# Rezoning Transportation Analysis

Petition Number: 2020-166

Date	Description
11-30-20	First Review (EL)
12-28-20	Second Review (KP)

SCHEMATIC SITE PLAN

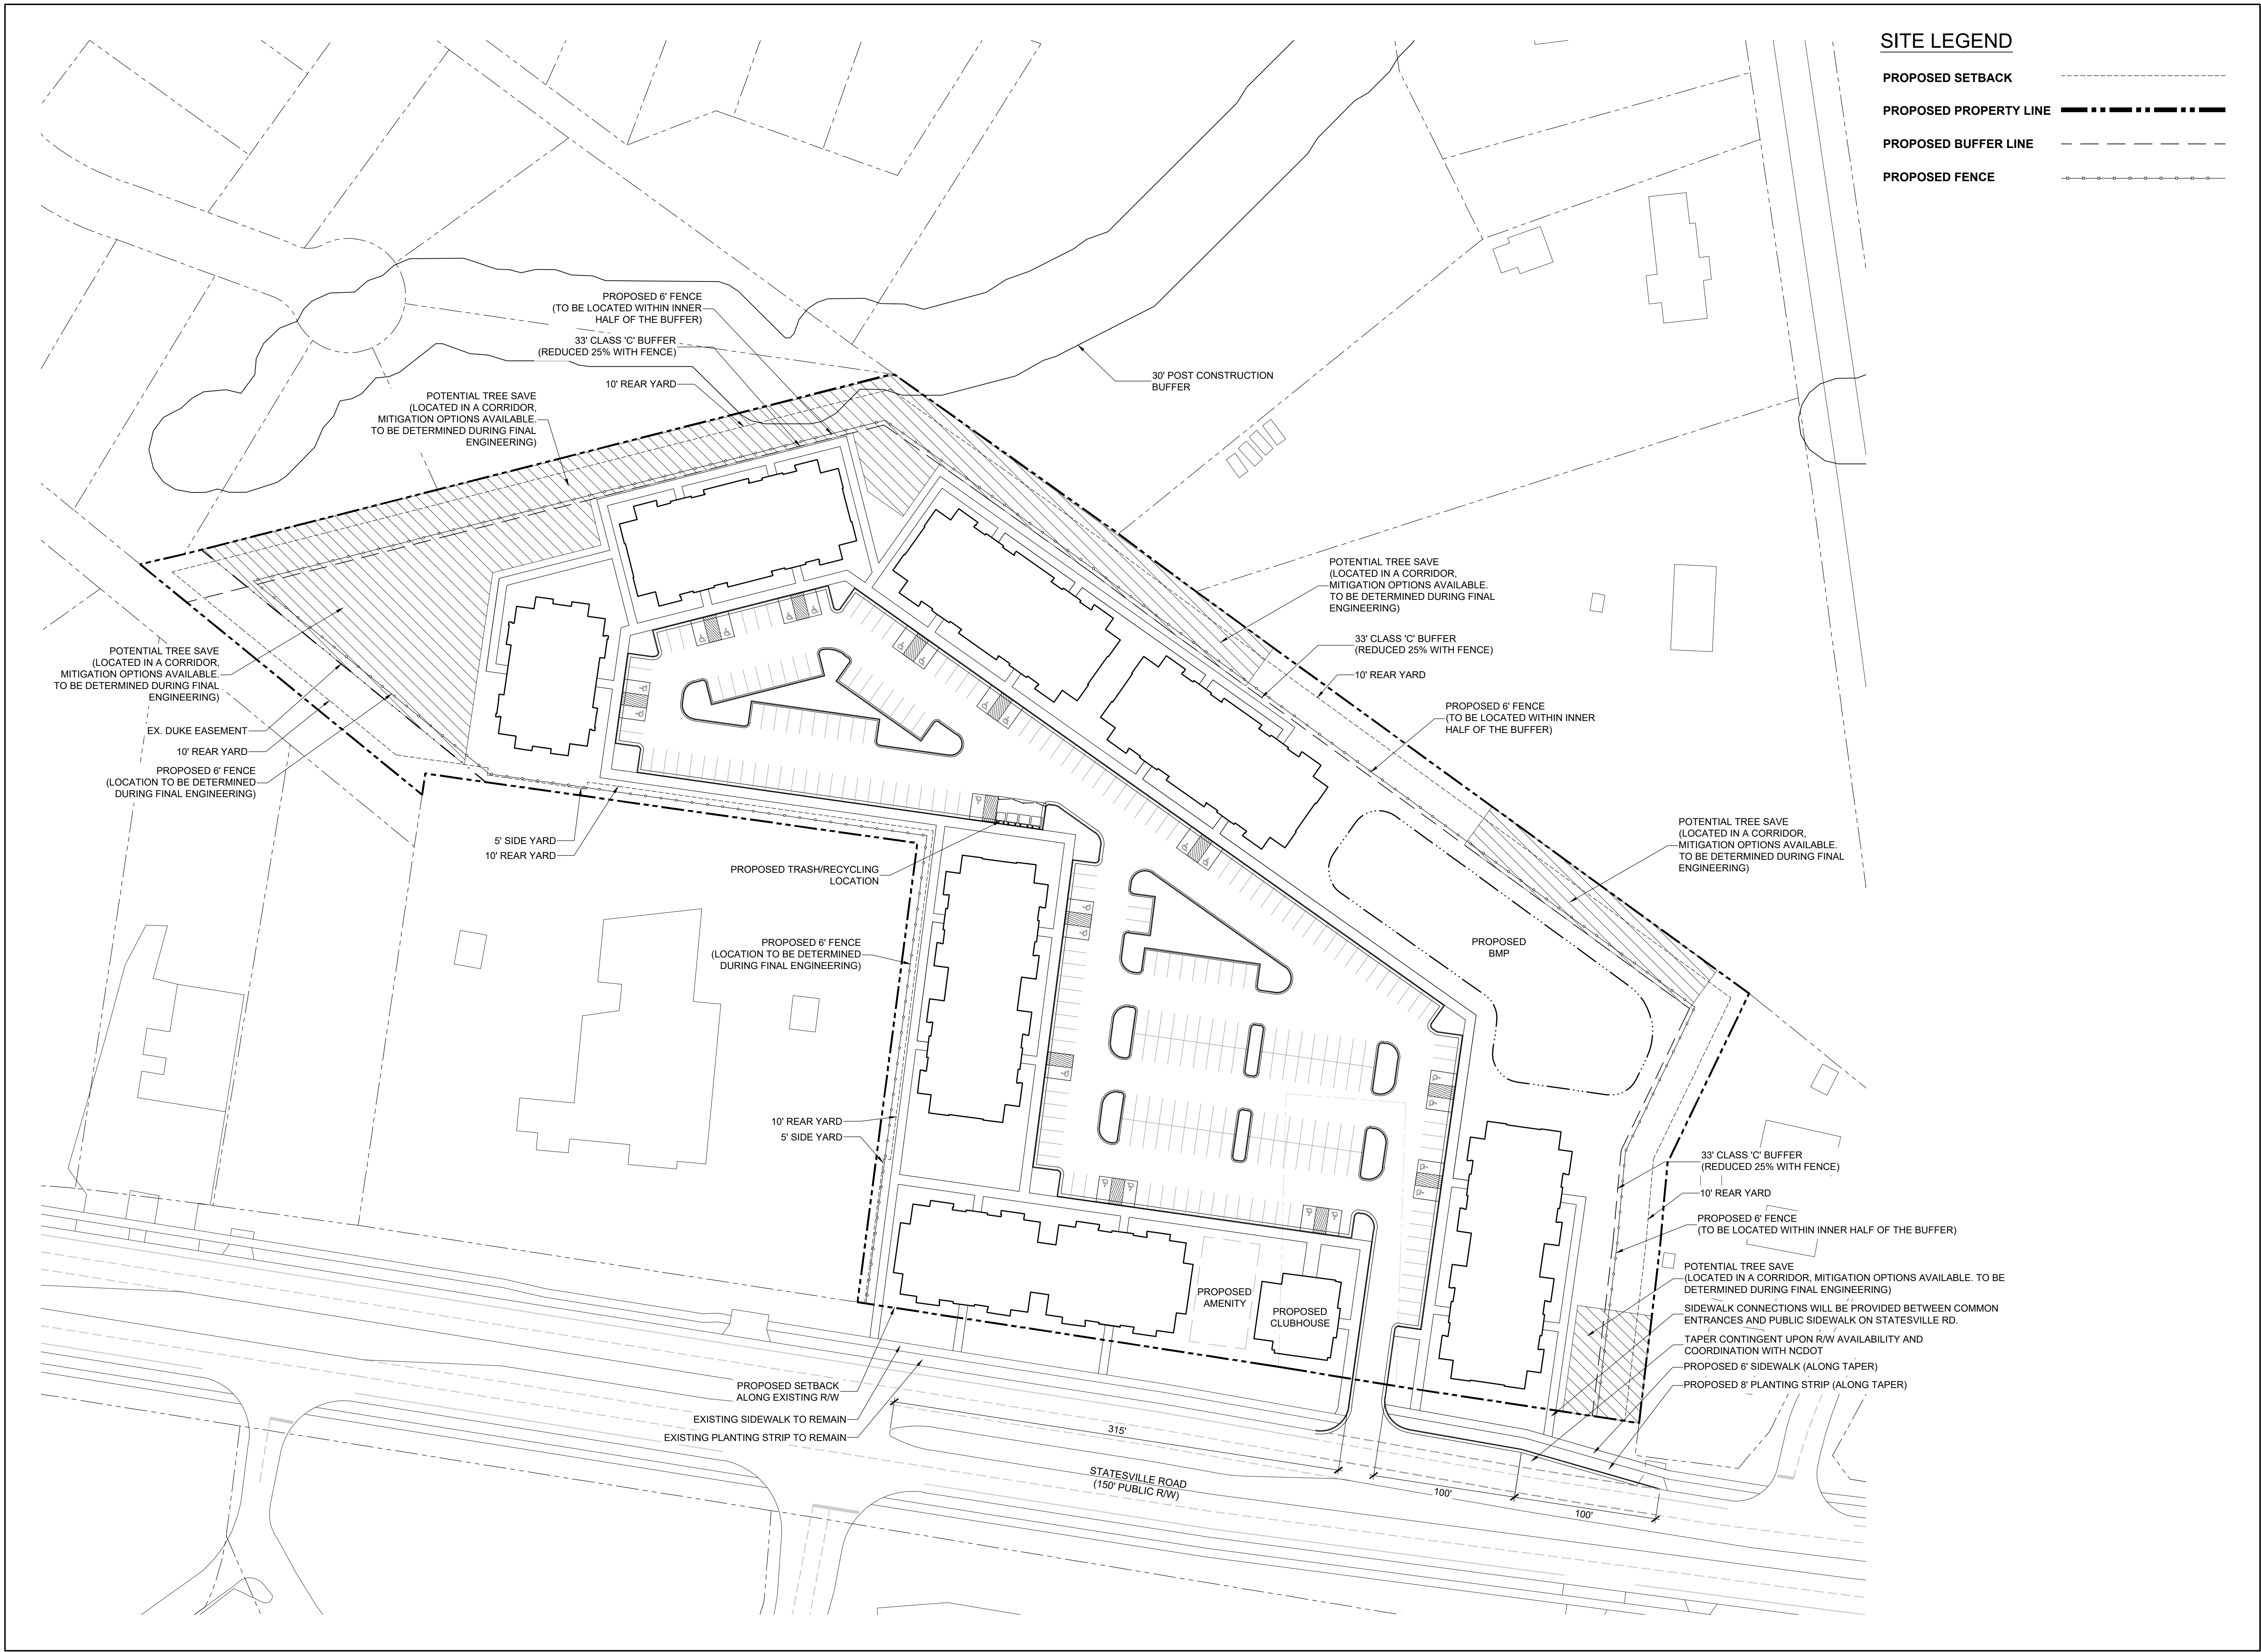
**Update to Comment as a result of the 12-15-2020 Site Plan:** Please include the taper and storage lengths of the turn lane within a conditional note and on the site plan. Also, please show the striping on Statesville Road.

SCHEMATIC SITE PLAN

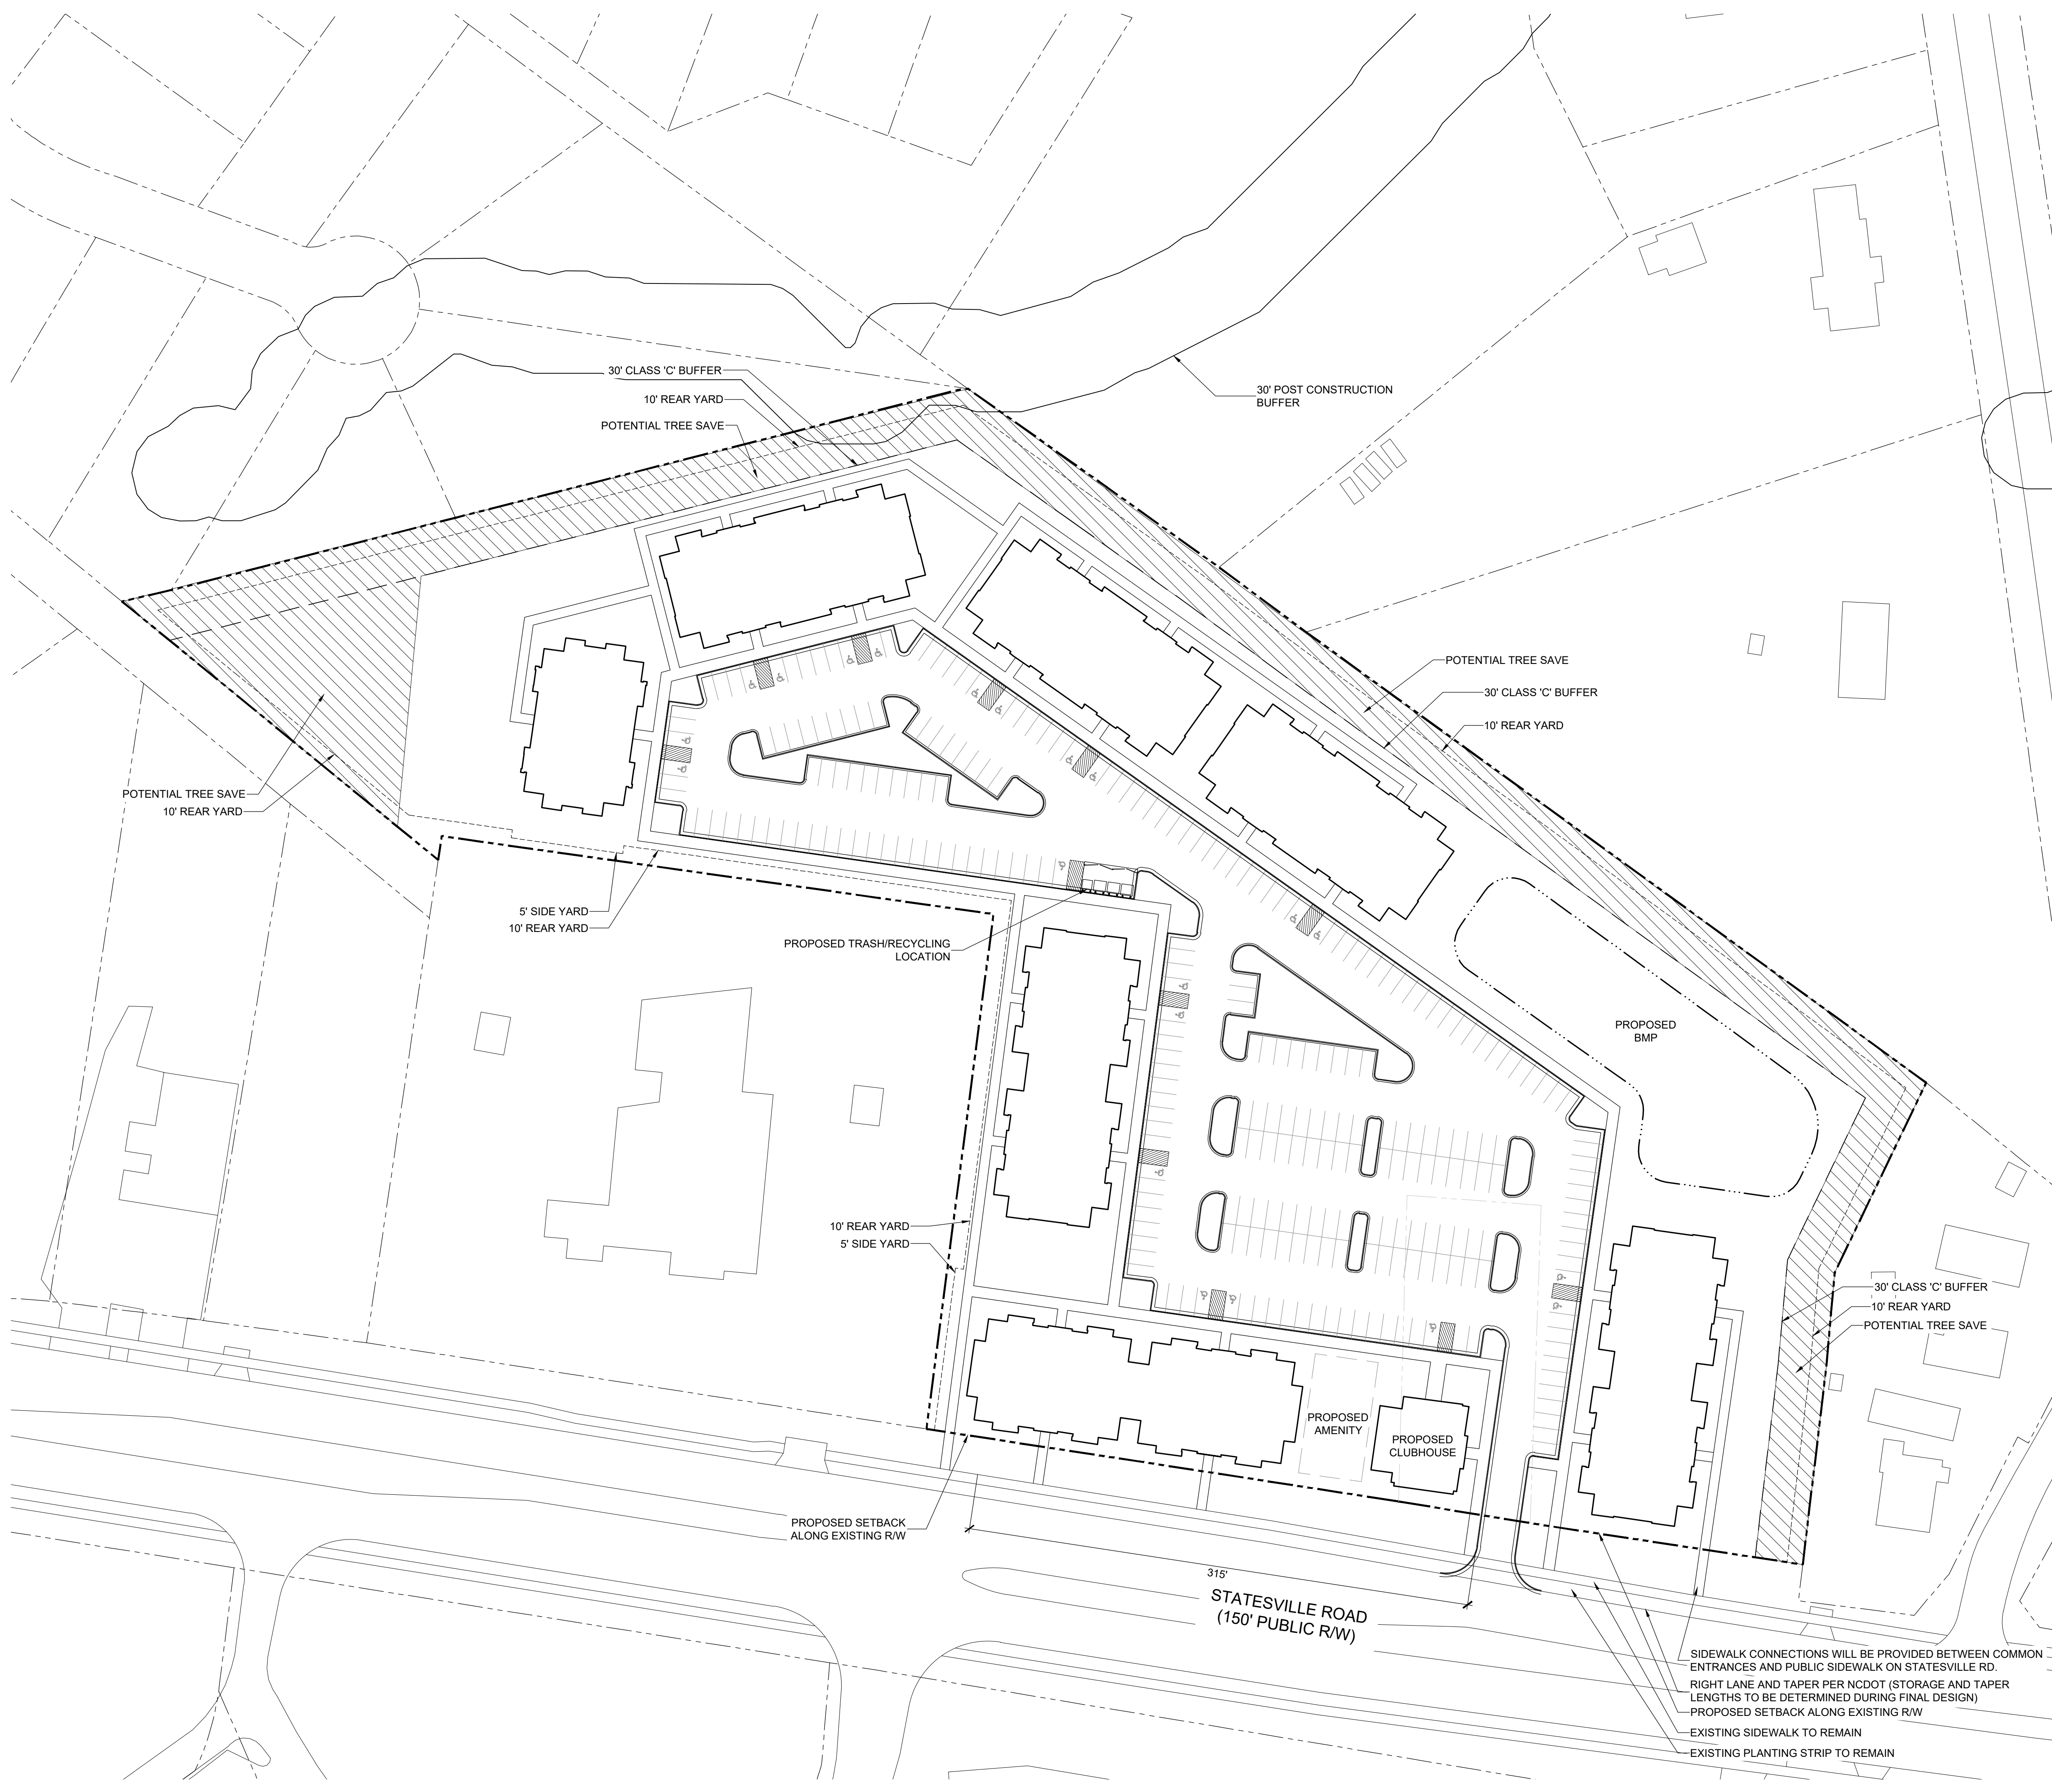
3. Revise the site plan and conditional note(s) to relocate the proposed access on Statesville Road approximately 315-feet to the existing left-turn lane taper on Statesville Road. Provide a northbound right-turn lane with 100-foot storage and 100-foot taper at the relocated access on Statesville Road, as required by NCDOT.
